MEMORANDUM

To: FILE
From: Richard Knowland
Subject: Application ID: 2014-038
Date: 6/18/2014

Comments Submitted by: Marge Schmuckal/Zoning on 5/6/2014

SHEET NUMBER
C09
12 OF 113

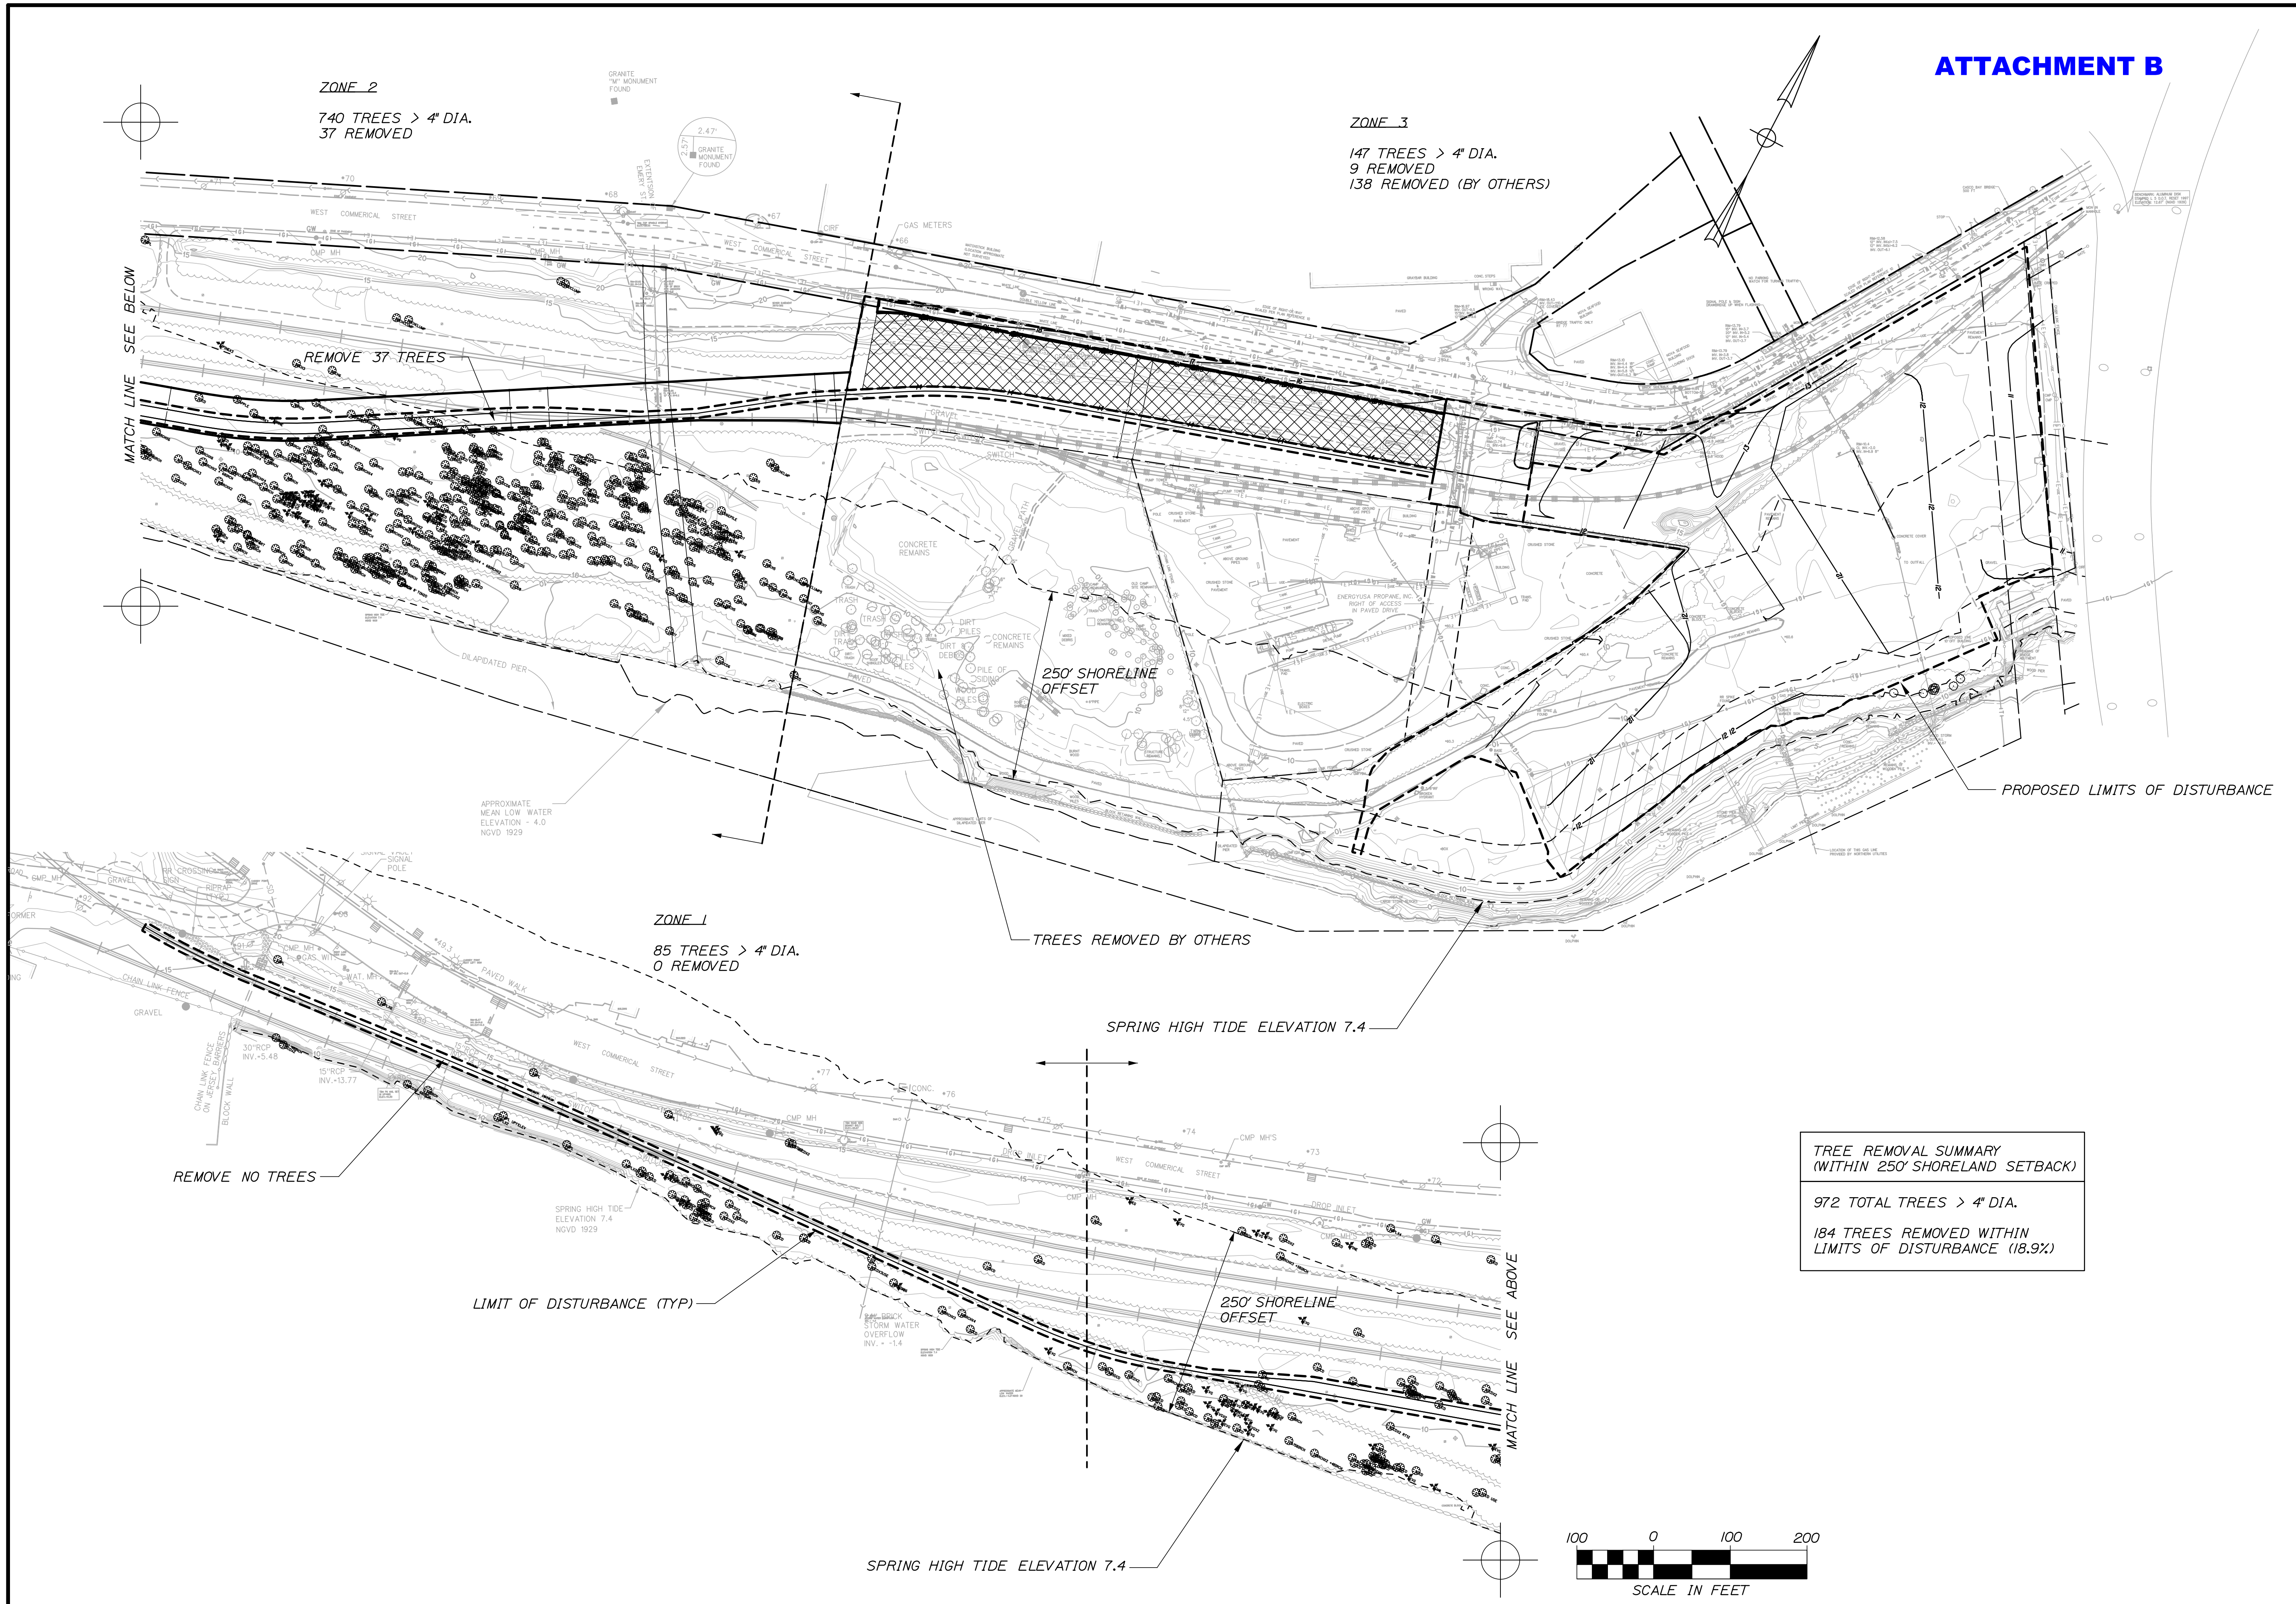
My second comment regarded meeting the shoreland requirements of clearing vegetation. The response was that the final construction site plans will show what is to be remove. I could not find a plan with sufficient detail that response to my request. As offered. I would like backup calculations to be provided so that I can determine compliance with the Ordinances. Please let me know the specific sheet number on which the information is provided.
